COUNTY COUNCIL'S RESPONSE TO CONSULTATION ON THE FOLLOWING DEVELOPMENT PROPOSAL

Application No: 21/00503/FUL

Proposal: Use of the site for the storage of operational vehicles, elevational alterations, associated parking, vehicle barriers, guard hut and associated infrastructure.

Location: Warehouse Car Park, Land at West of Southam Road(Banbury 200), Banbury,OX16 3AE

Drawing Title
**External Lighting
 Lux Level Plot**

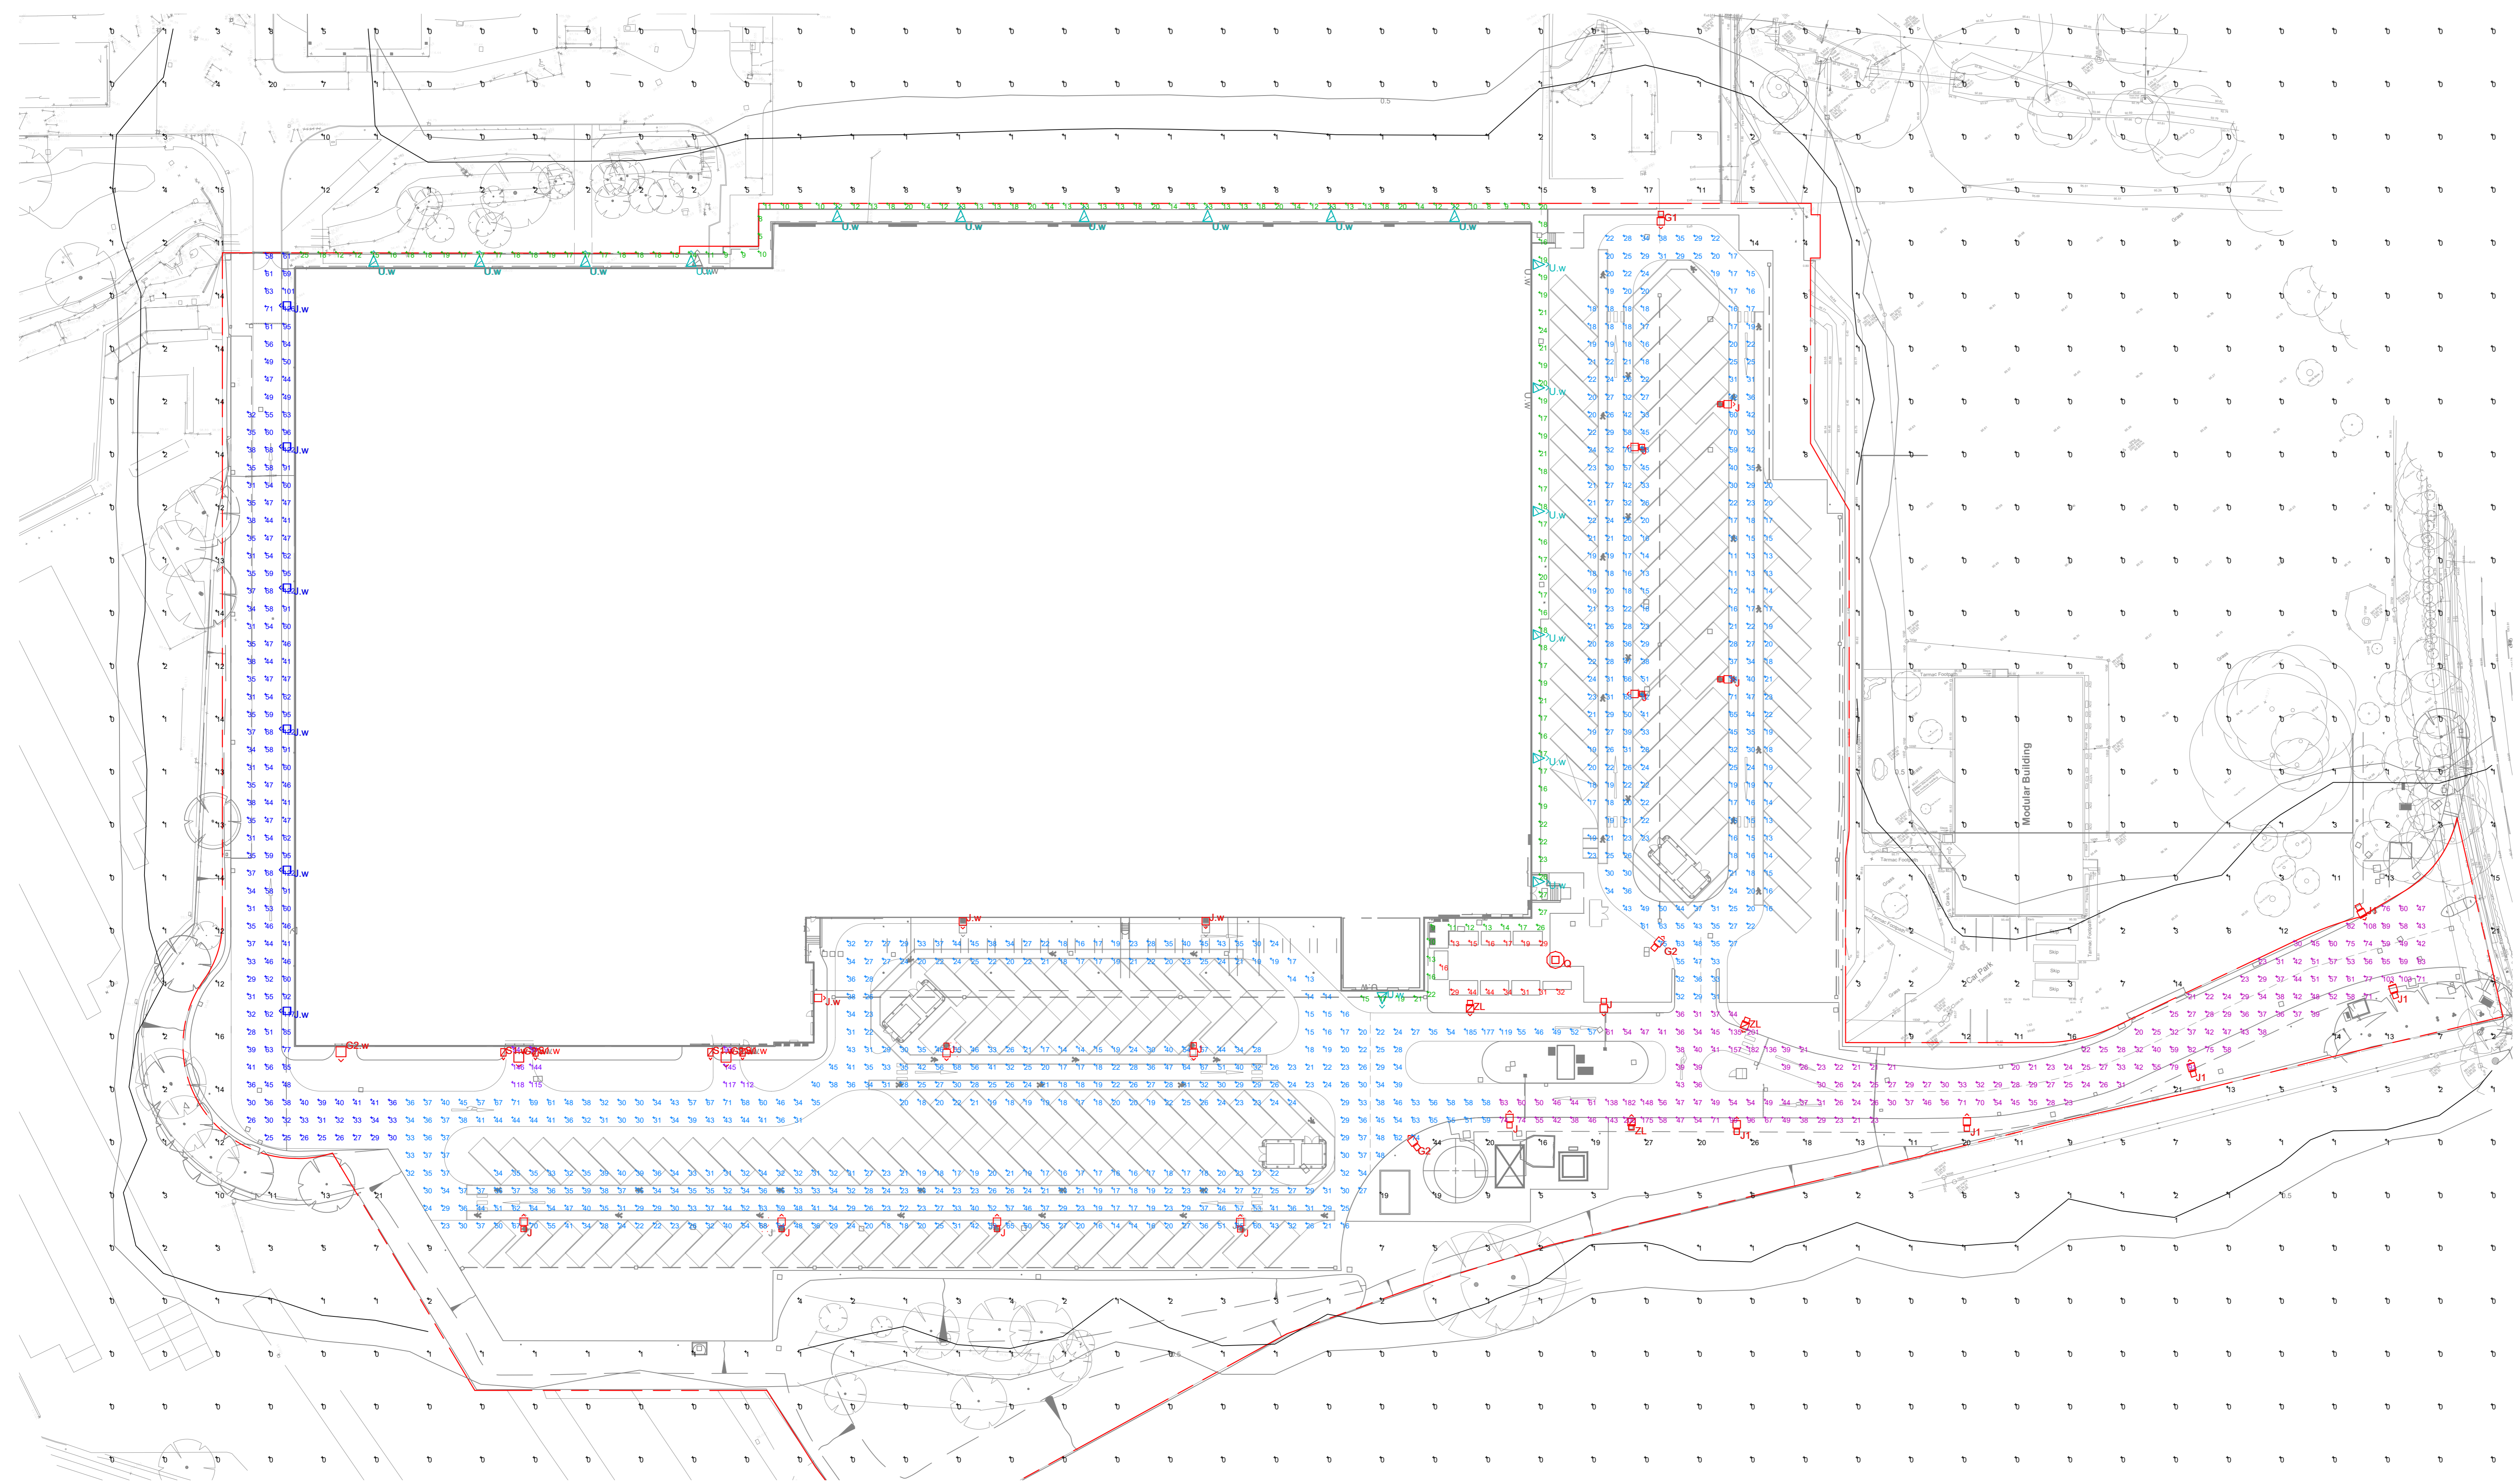
- The external lighting Lux Plot drawing no. 10336-PL-100 Rev OCC Street lighting Officers for comments, Applicant. The lighting arrangement is not be to OCC specification so required to establish if this road a private road. There is no indication as to what category or classification the developer is trying to achieve with the lighting arrangement/levels. The lighting levels seem higher to what OCC would specify and the colour temperature is 4000k which is higher than we would use which is 3000k. The light the fittings are similar to what we would approve.
